Arun District Council
Arun Civic Centre
Maltravers Road
Littlehampton
West Sussex BN17 5LF
Planning & Building Control General Enquiries
Tel: (01903) 737756 Fax: (01903) 730442
Dx: 57406 Littlehampton
Minicom: 01903 732765
e-mail: planning@arun.gov.uk
website: www.arun.gov.uk/planning

Our Ref: K/1/12/

16th March 2012

Side extension to provide garage and store (re-submission following K/25/11)
29 Golden Avenue East Preston

DRAWING TITLE
PROPOSED FLOOR PLANS

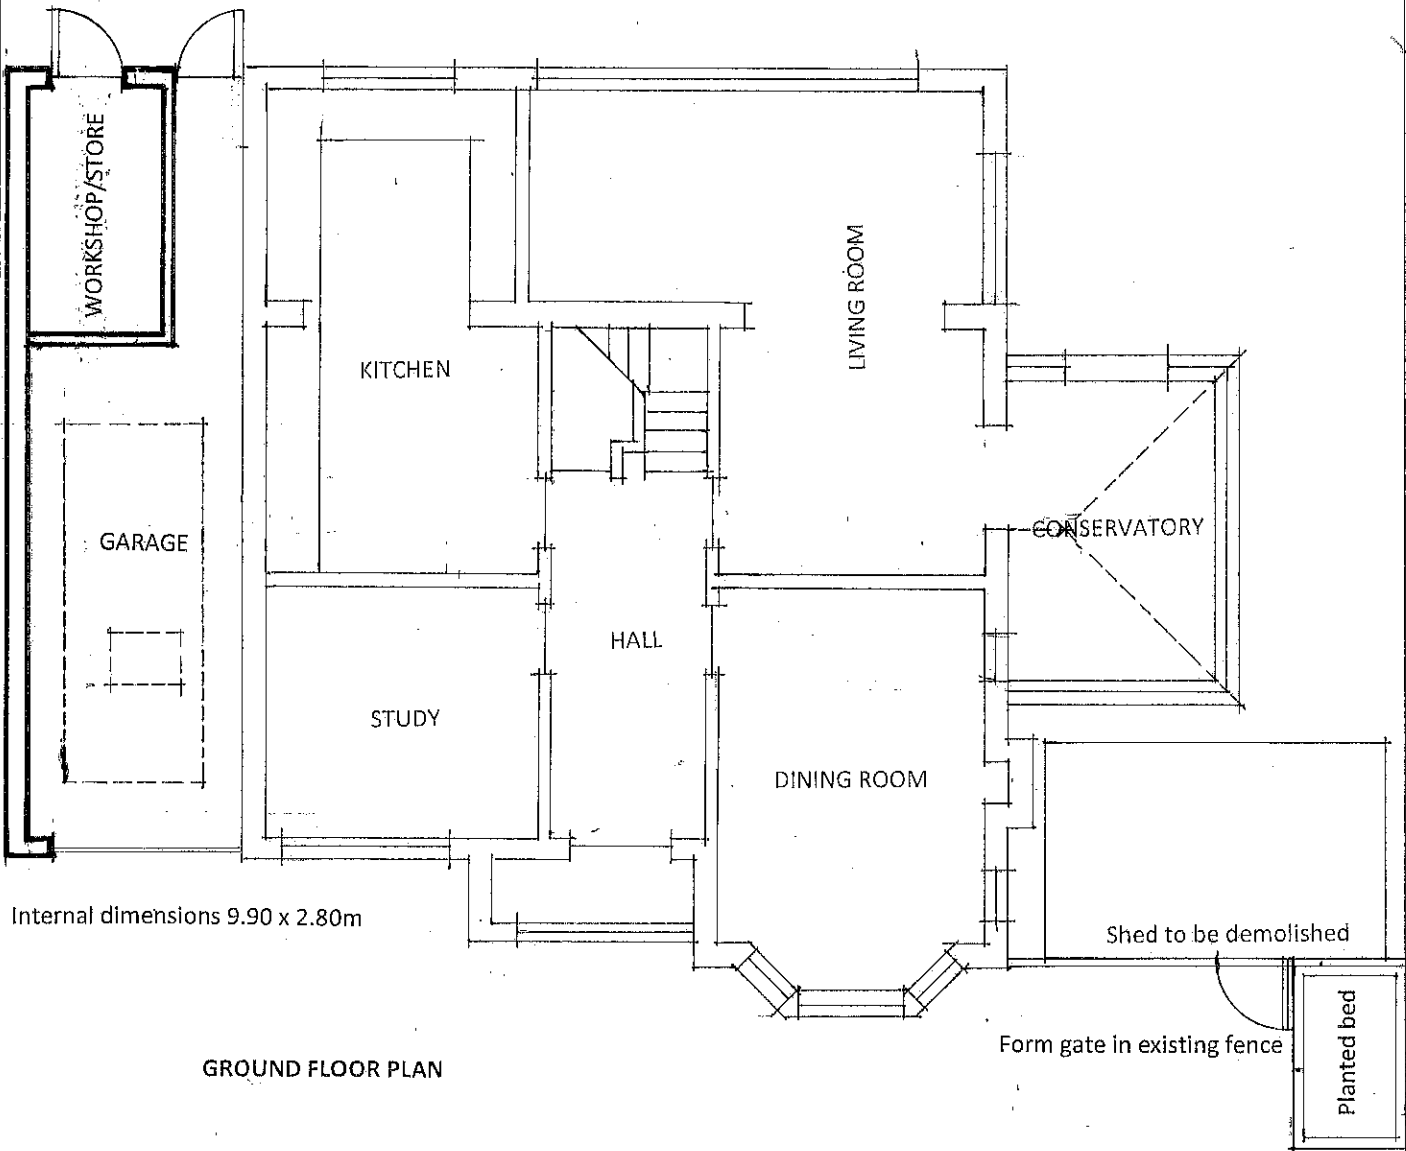
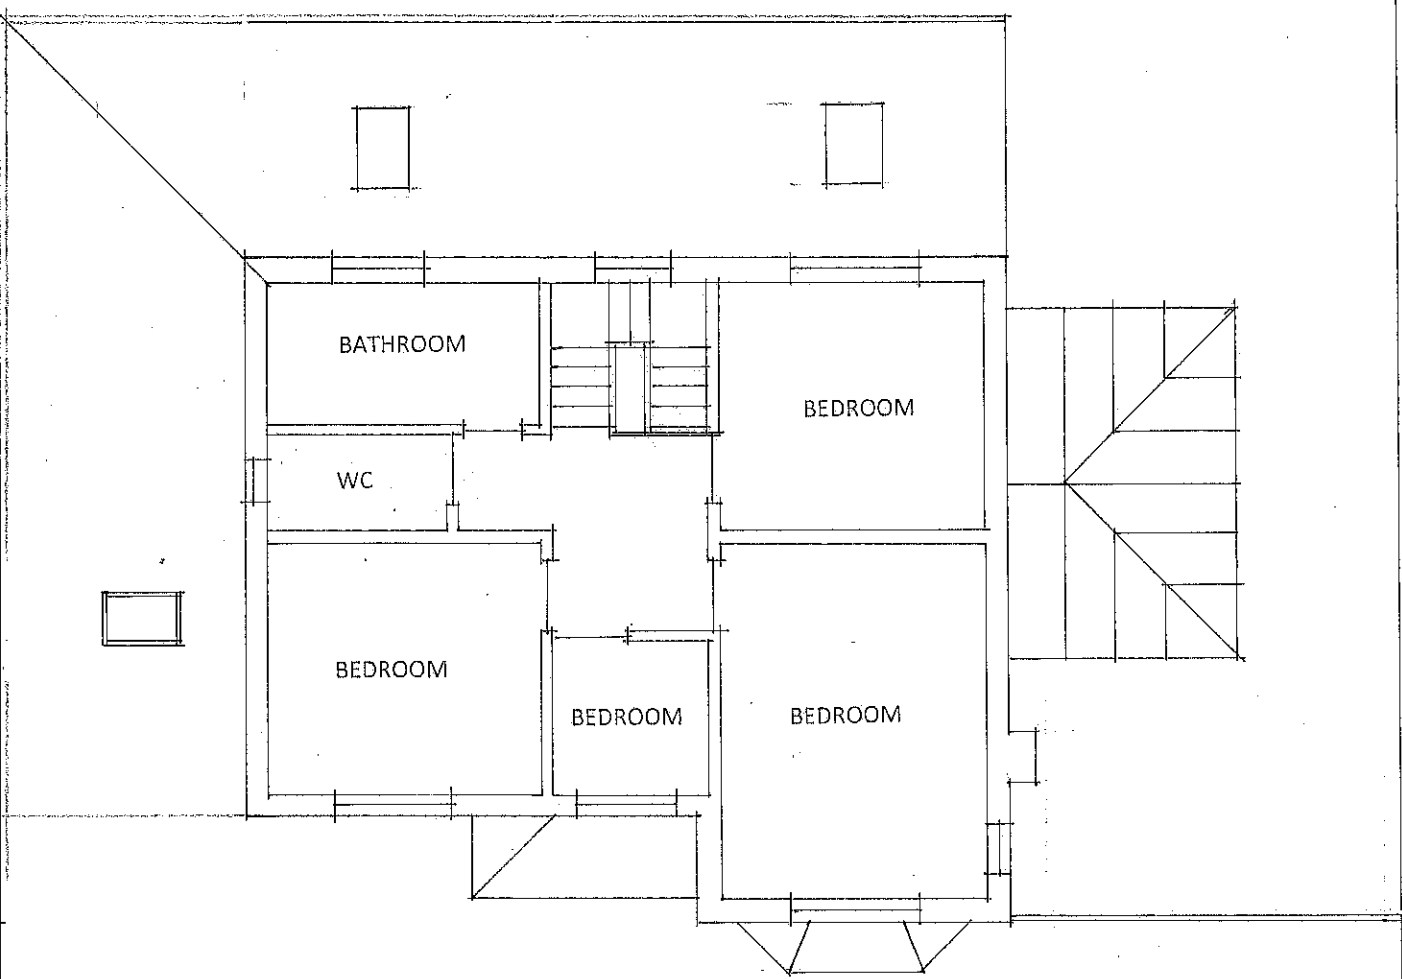
- *Building along the boundary edge will be detrimental to the neighbouring property when carrying out maintenance work along the boundary (which Council understands is the responsibility of the neighbouring property) and it will mean that when the applicant needs to carry out maintenance to the north side of the proposed development it can not be carried out without access from the neighbouring garden.*

- *There is also a concern that use of the workshop to the rear of the garage will be a*

noise nuisance to the neighbouring property. Are there any limitations to be put upon its use?

PROPOSED ELEVATIONS SHEET 1

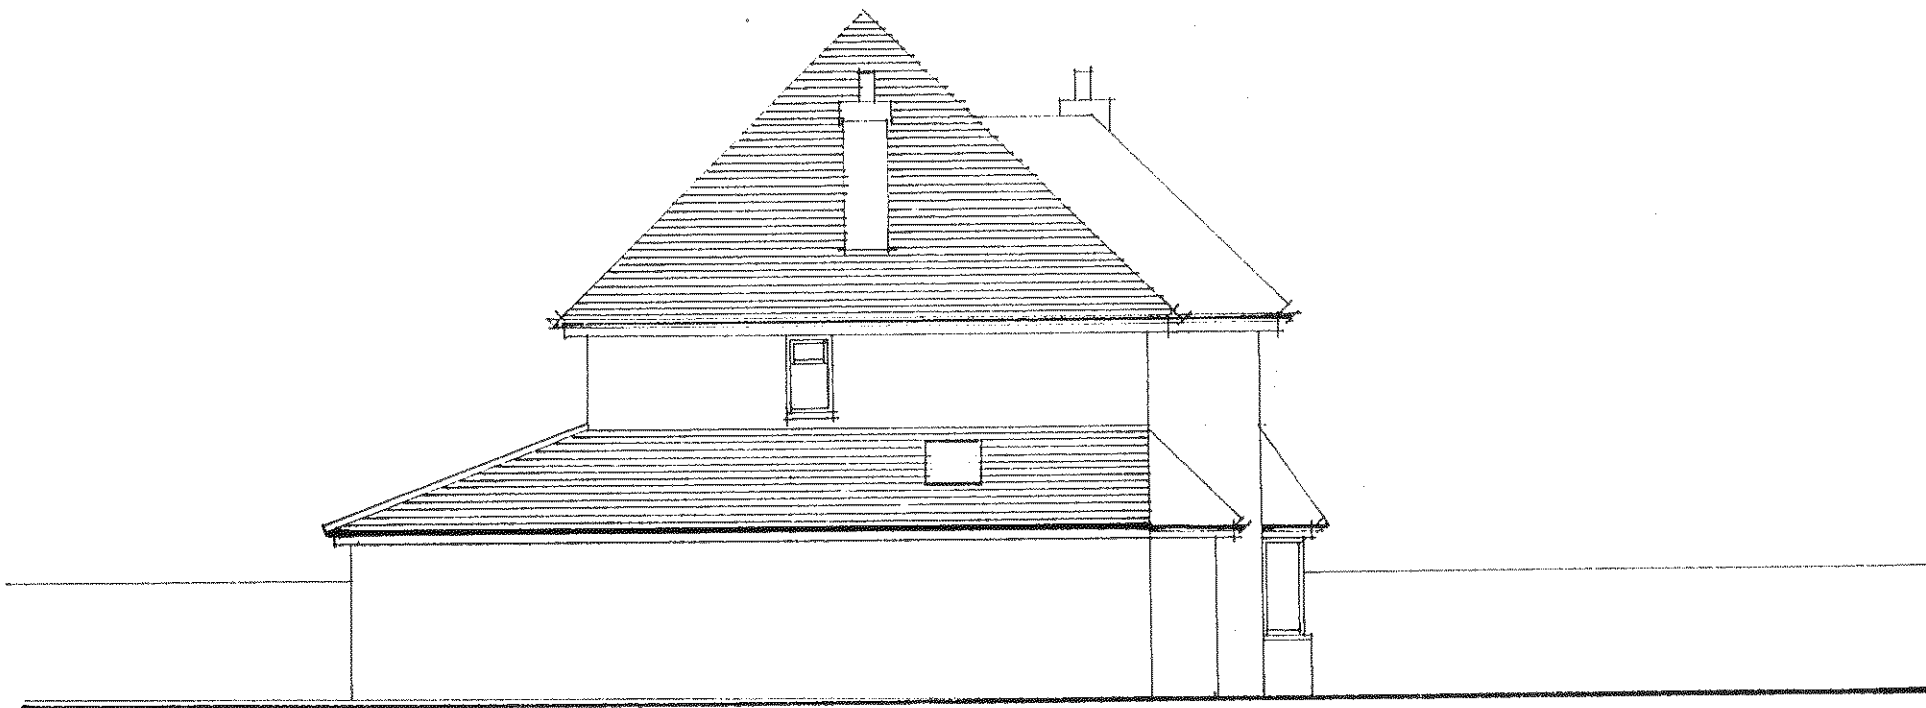
- *It is an overdevelopment of the site*
- *It will be detrimental to the character and appearance of the street scene, as it will detract from the open nature and feel of the Golden Avenue and the parish as a whole. Given that there is already a conservatory added to the south of the property a development on the other side will mean that there has been infilling towards the boundary on both sides of the property. If other properties followed suit the appearance of the houses along Golden Avenue would appear more like terrace properties than detached.*

- *It will be overbearing and intrusive on the neighbouring property*
- *It will mean a loss of light to the living rooms of the neighbouring property (i.e. unneighbourly to Number 27 Golden Avenue)*
